Our Ref: A/69/08/

27th June 2008

Single storey extension between house and garage, partial conversion of garage to form kitchen.

22 Oakwood Drive Angmering

EXISTING B PROPOSED
LAYOUTS

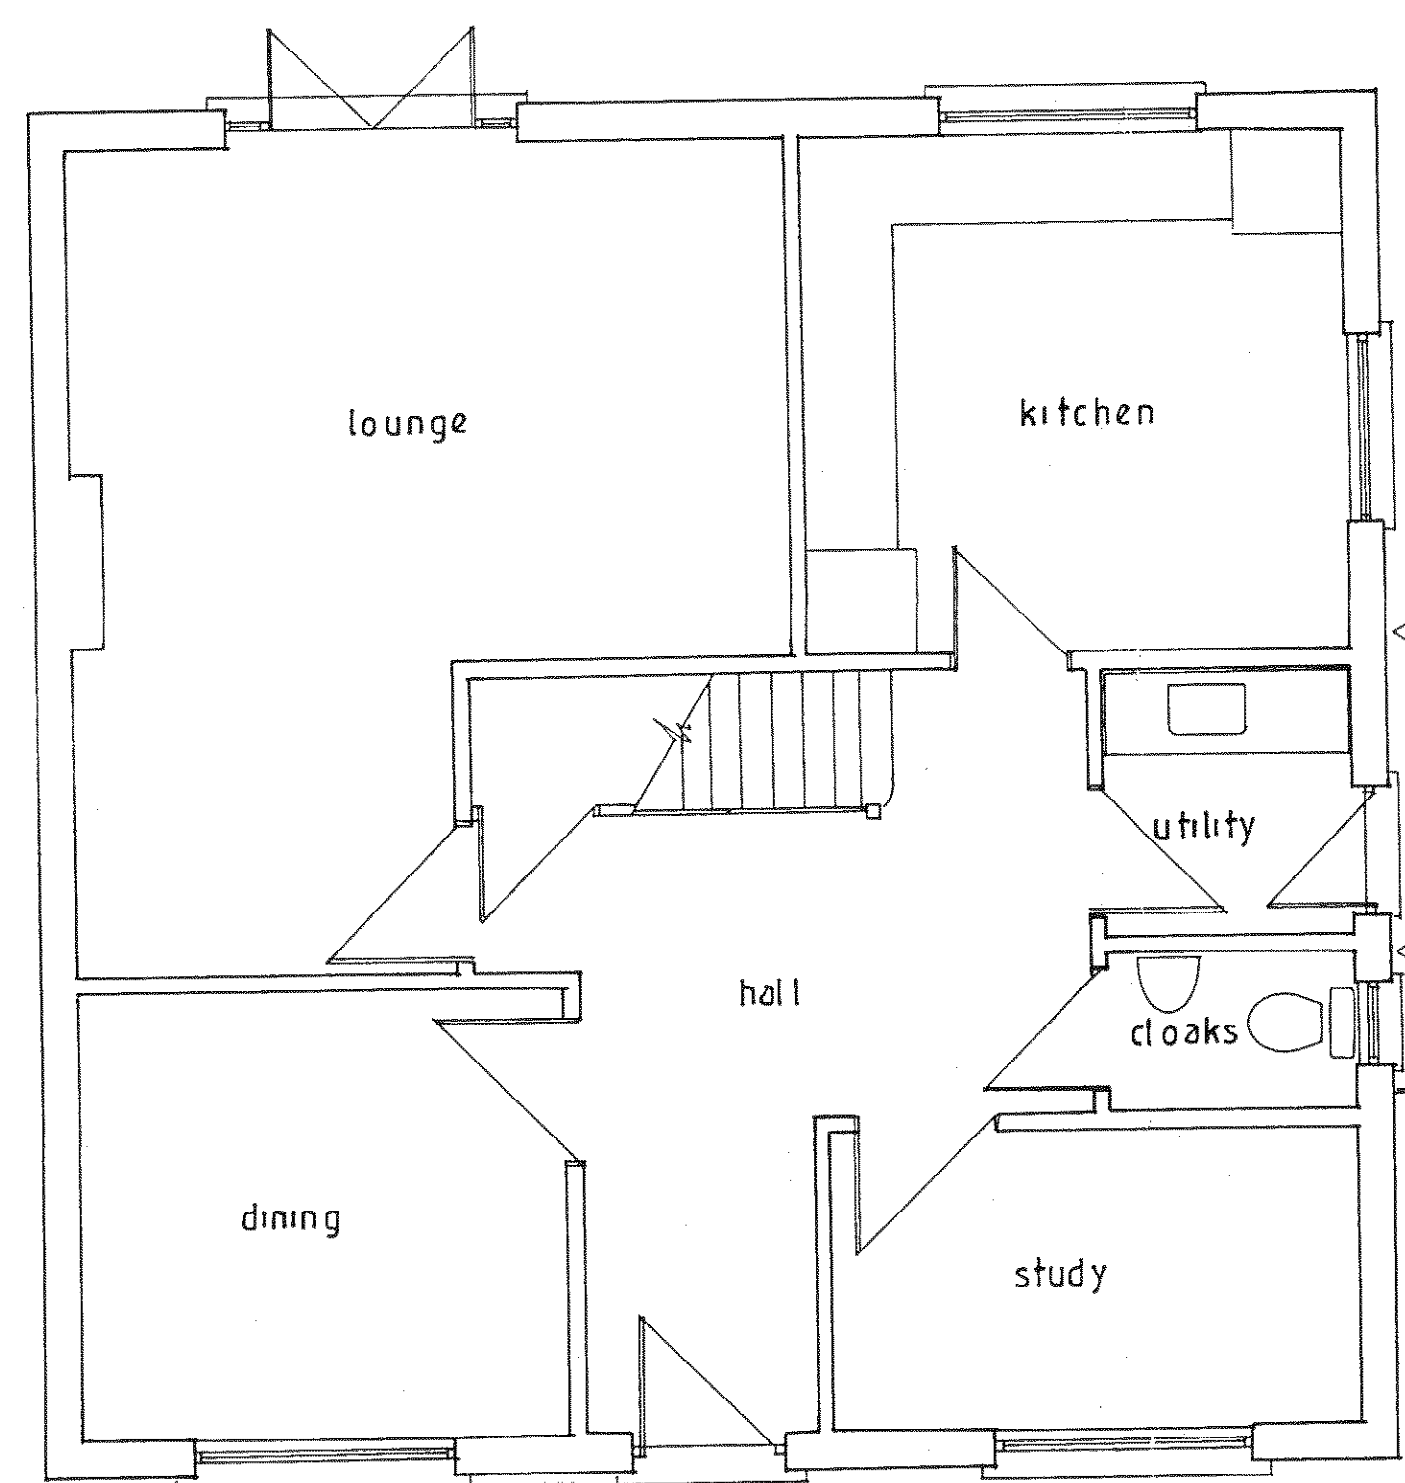
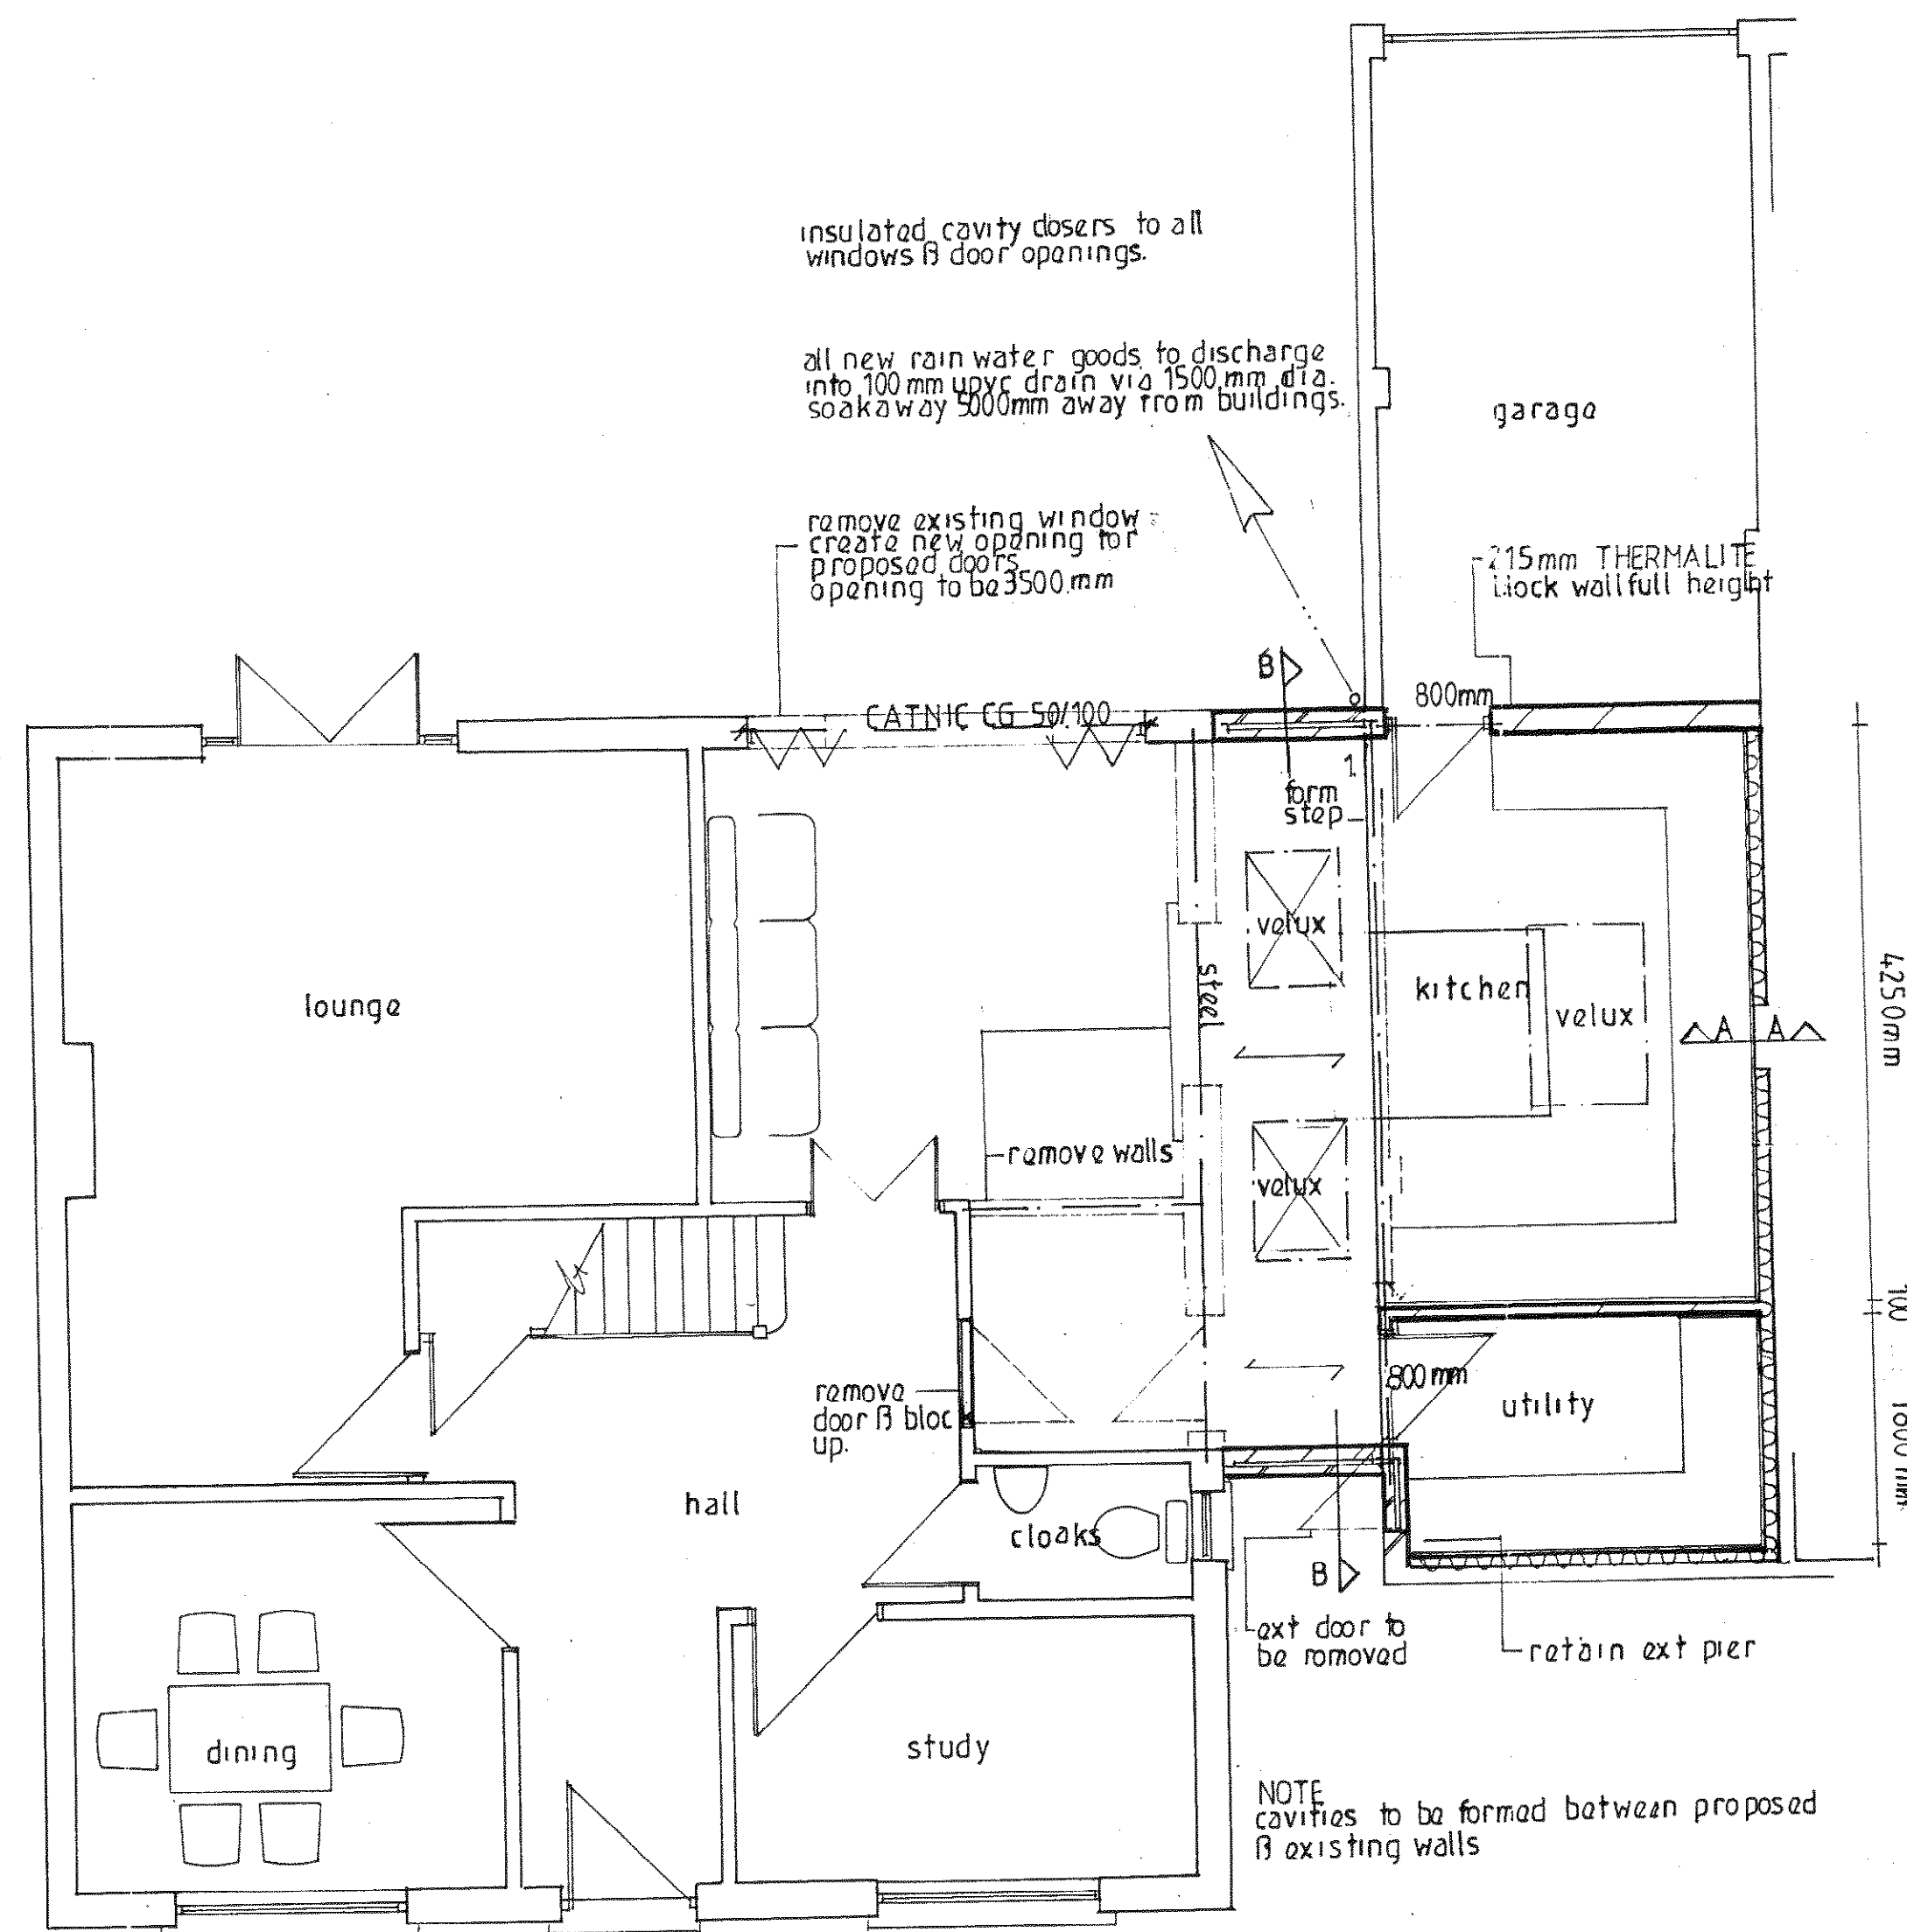
We object to the design and appearance of the building because of the number of conflicting roof lines and lack of light and ventilation in the kitchen and utility room
